Application No: 19/02915/DISC

Proposal: Discharge of Condition 13 (Access full details- Use of land as a construction compound incorporating storage area, site offices and car parking) - 19/00607/F

Location: Land At Skimmingdish Lane And Land And Roundabout At Bicester Road Launton

Transport Development Control

Drawing Title: ACCESS TO COMPOUND A1 GENERAL ARRANGEMENT

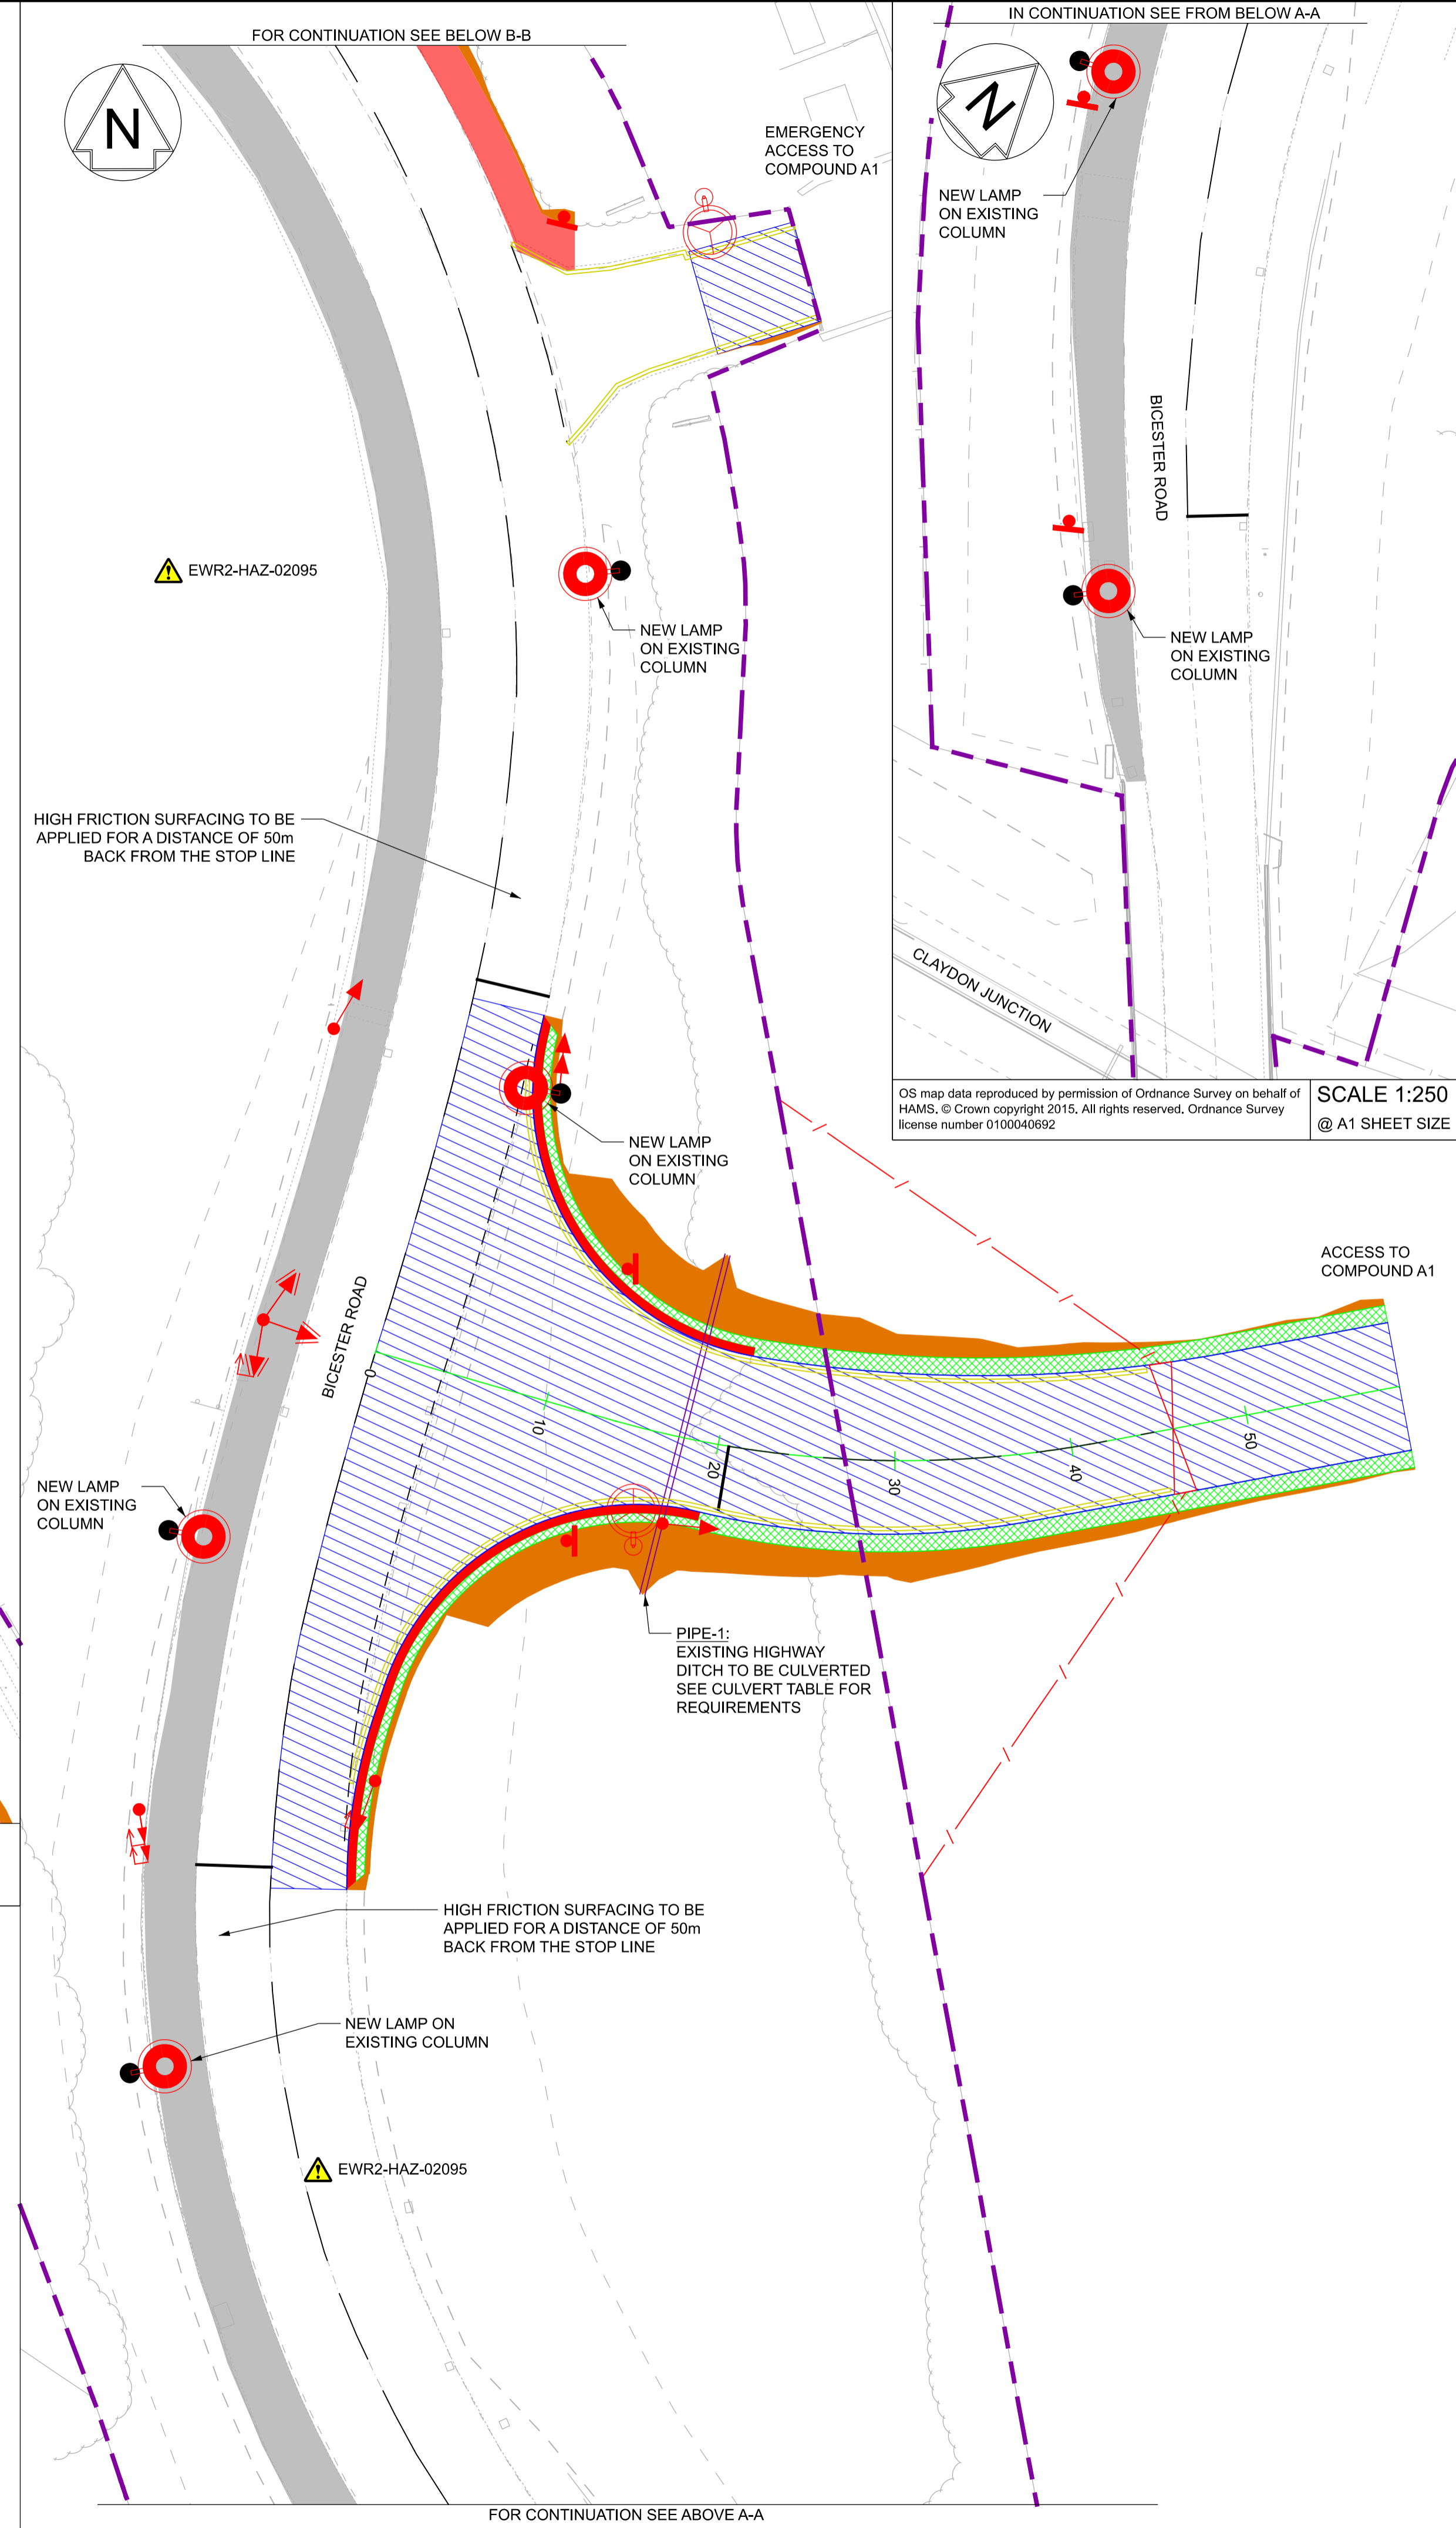
- Our Road Agreements team is currently reviewing a technical submission for this junction and has provided initial feedback.
- To date, no detail on the design and operation of the proposed traffic signals has been submitted to satisfy OCC
- Satisfactory detail would need to be submitted in order to remove our objection to the discharge of this condition.
